Consultation Response from: KC Environmental Health (Pollution & Noise Control)
2021/91792 - Lower Sowood Farm, Healey Lane, Brierfield, Dewsbury, WF12 0NT
Erection of extension and alterations to outbuilding to create dwelling forming annex accommodation associated with Lower Sowood Farm, Healey Lane, Brierfield, Dewsbury, WF12 0NT
Date Responded:
24th November 2021
Responding Officer:
Natalie Heaney
Responding Ref:
WK/202116446

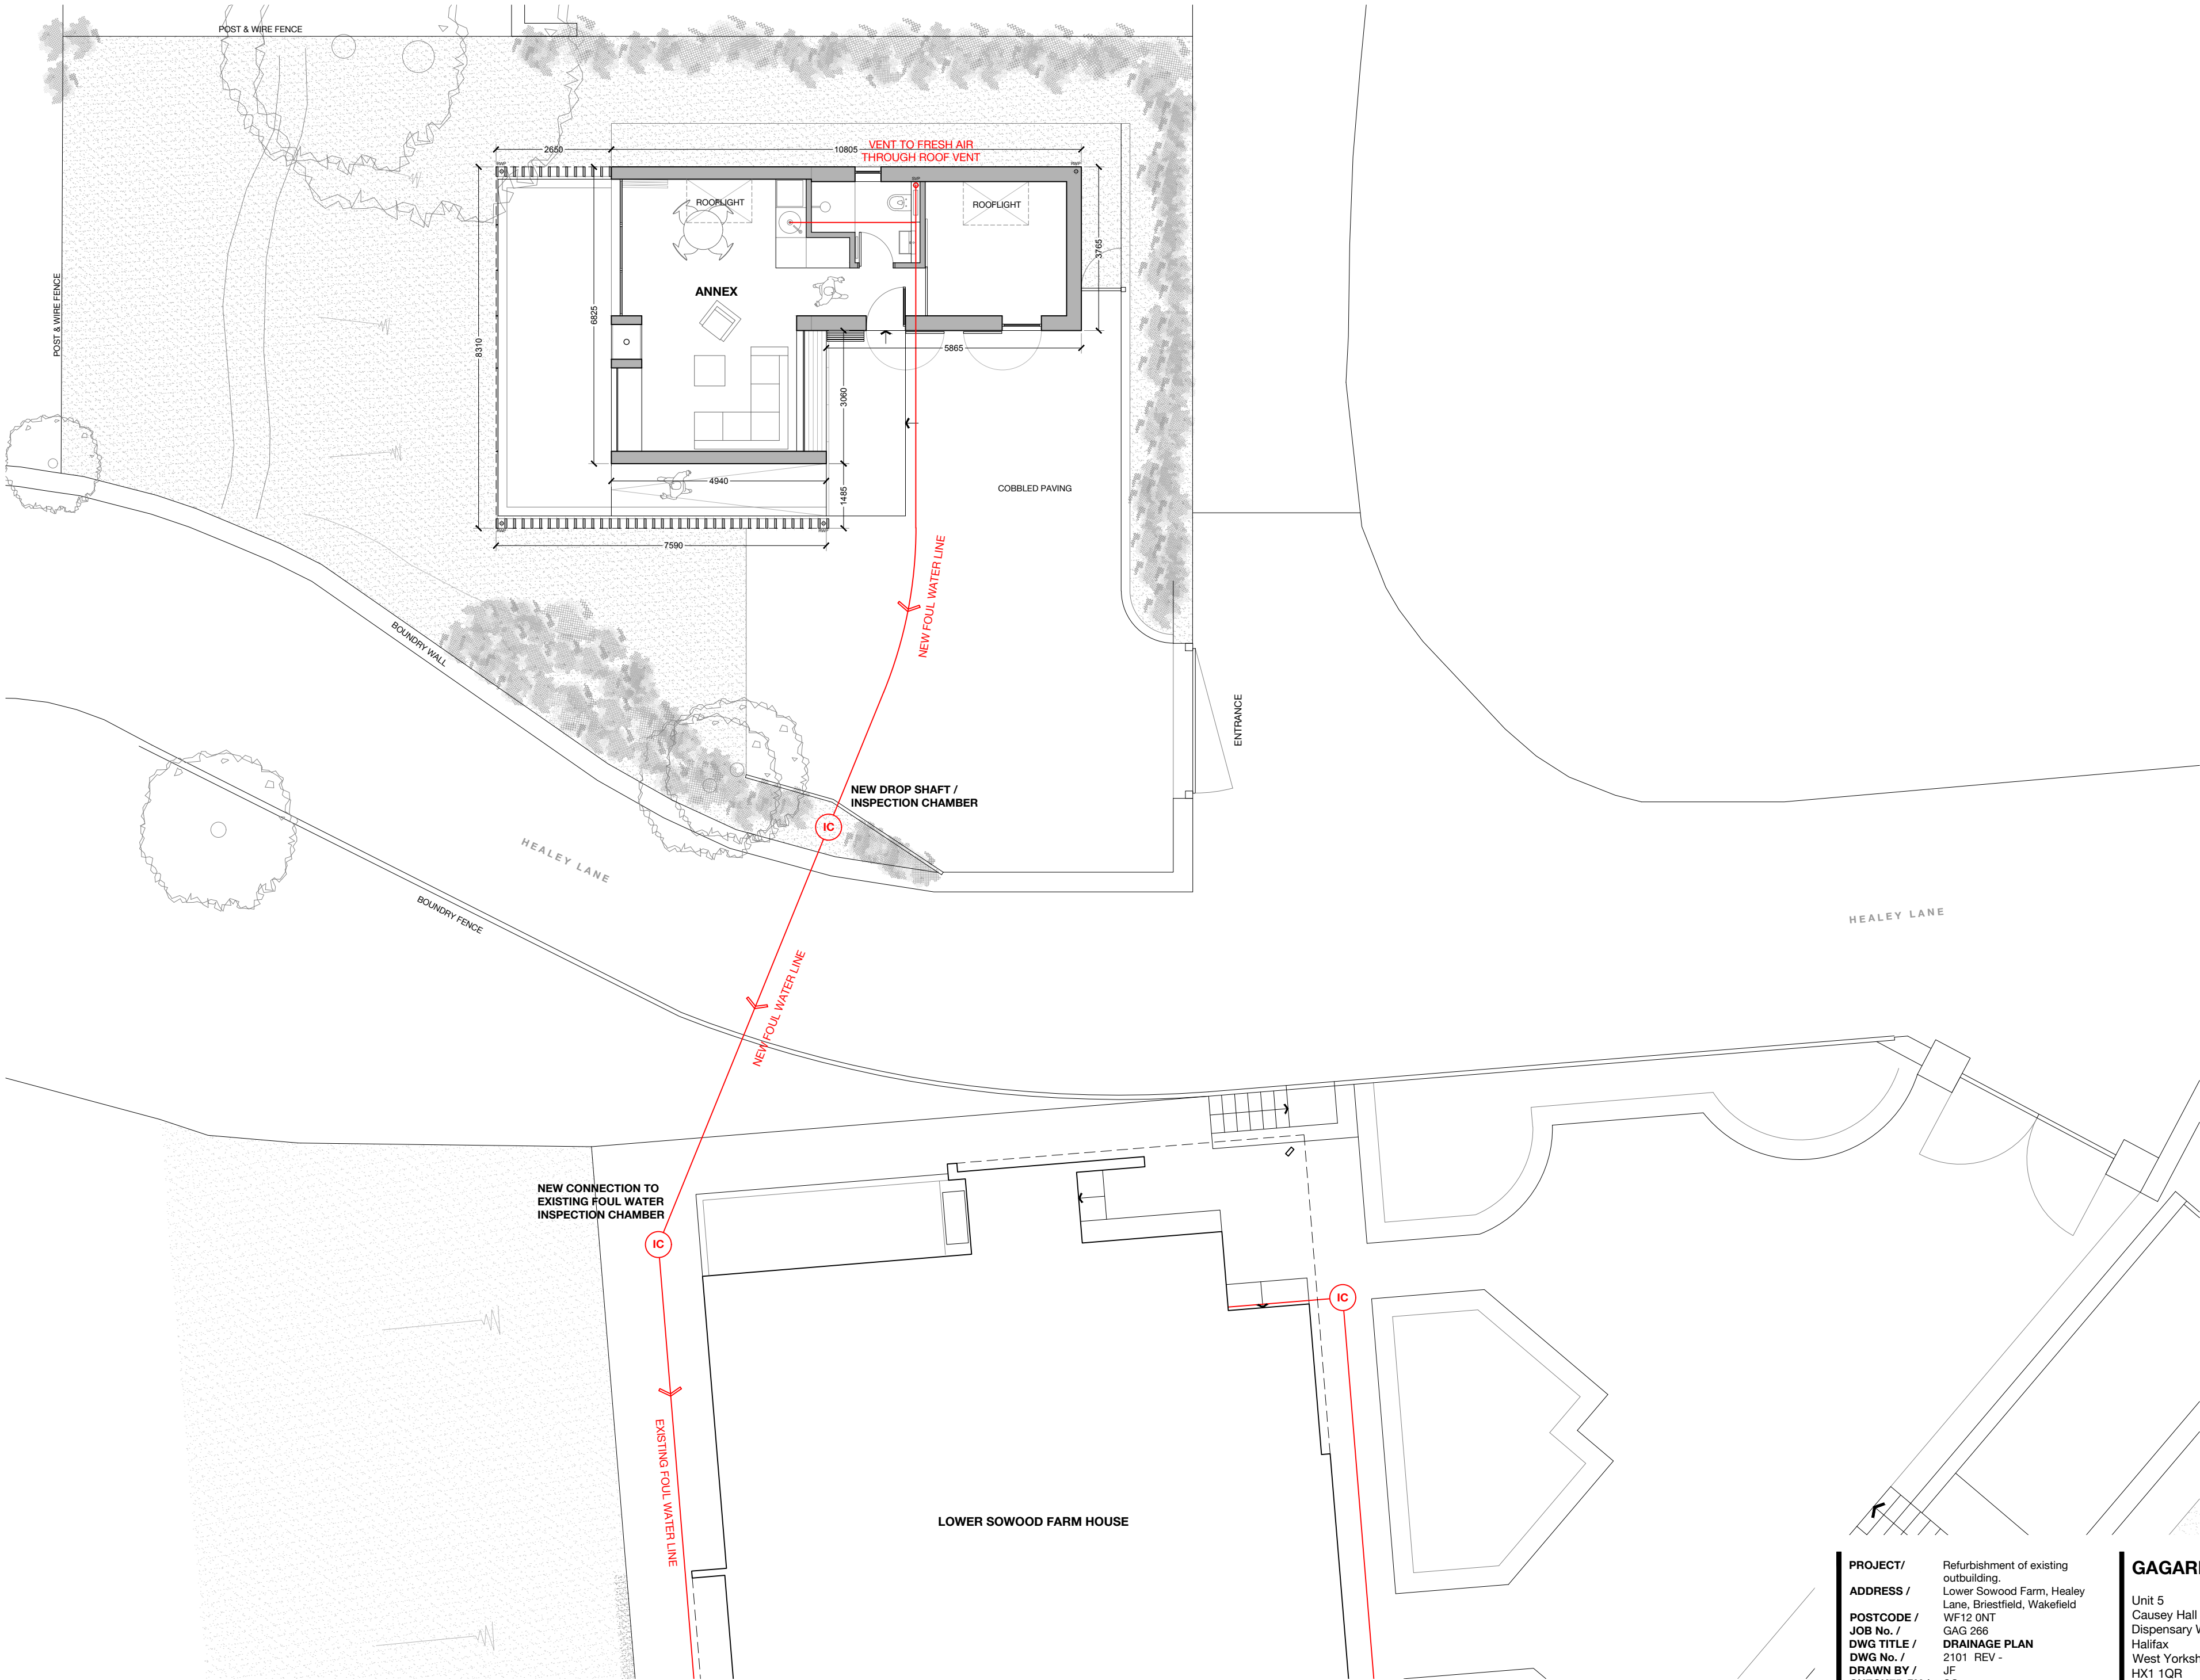
Now, a Drainage Plan by Gagarin Studio dated 19th October 2021 (drawing no. 2101 REV) has been submitted. The plan shows that the annex property will be connected to the existing foul water drainage system that serves Lower Sowood Farm House. In principle, this is satisfactory. However, we still require evidence that confirms that the existing system is of sufficient size and capacity to serve the proposed outbuilding. These must be presented in support of the application and until adequate provision for foul drainage has been demonstrated, the application should not be determined.

It is understood that a mains drainage system is not available for the development. No detailed information has been provided regarding the proposals for providing an adequate system of foul water drainage which will be required by the building regulations. To ensure that it is feasible for the building regulations to be met and also avoid the possible need for a further planning application relating to the construction of a septic tank it is recommended that before determining the application the applicant provides detailed information to show how a satisfactory foul drainage system is to be provided for the proposed development. The submitted information needs to demonstrate that the requirements of The Building Regulations 2010 Approved Document H, Drainage and Waste Disposal can be met and if a small sewage treatment plant (i.e. septic tank or package treatment plant) is proposed that the “General binding rules for small sewage discharges” can also be met. The details must therefore include the following information:

- a) The location of the tank (which must not be so near to any inhabited building as to be liable to become a danger to health or a source of nuisance (a minimum of 7m is required but over 20m and down slope is preferable) or in an area where there is a risk of flooding).

- b) The discharge details for the tank (which must not present any risk of contamination to any watercourse, underground water or drinking water supply).

- c) Details showing how adequate means of vehicular access will be provided to allow the tank to be periodically emptied and maintained.
- d) Calculations demonstrating that the tank will be of adequate capacity for the highest number of persons that may use the tank.

- e) If an existing tank is to be used, details of its condition / state of repair demonstrating that it is operating correctly and is impermeable to liquids

- f) Details of the necessary porosity and percolation tests carried out to establish the suitability of land that is to be used for any soakaway/land drainage of effluent.
